Arun District Council
Arun Civic Centre
Maltravers Road
Littlehampton
West Sussex BN17 5LF
Planning & Building Control General Enquiries
Tel: (01903) 737756 Fax: (01903) 730442
Dx: 57406 Littlehampton
Minicom: 01903 732765
e-mail: planning@arun.gov.uk
website: www.arun.gov.uk/planning

Town & Country Planning Act 1990 (as amended)
Town & Country Planning (Tree Preservation) (England) Regulations 2012

Application No: A/100/21/T
Site Address: Land to North of New Road Angmering
Description of works: Fell 12 No. Monterey Pine trees

Thank you for your internet representation made on 30th June 2021 which has been recorded as an objection with the comments as follows:

Tree Area 1

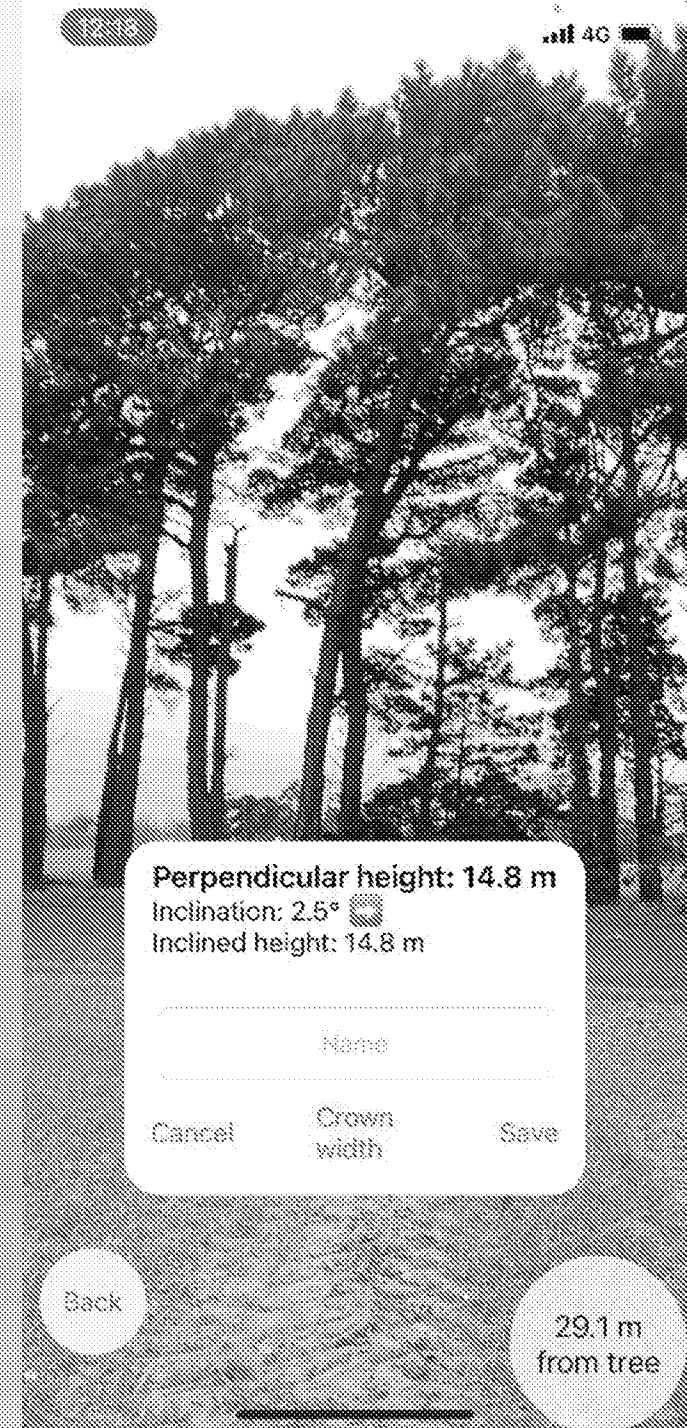
No evidence has been provided about the extent to which the required infrastructure is impacted by the current location of the trees and therefore the validity of the claim is not clear and further evidence and explanation should be provided by the applicant. Also the applicant has not clearly articulated why so many trees are proposed to be felled. Given the size of the trees and the spacing between, this would represent a large void in the current line of trees.

The trees proposed to be felled are part of a long line of identical trees and others in the area which are also similar. Beyond the obvious ecological impact, these trees support the retention of the character of the area. Unfortunately due to other developments in the area (particularly the dualling of the A259) we have already lost a huge number of historic trees so I urge the council to reject this application and request that the applicant find an alternative resolution which avoids destroying our local landscape further.
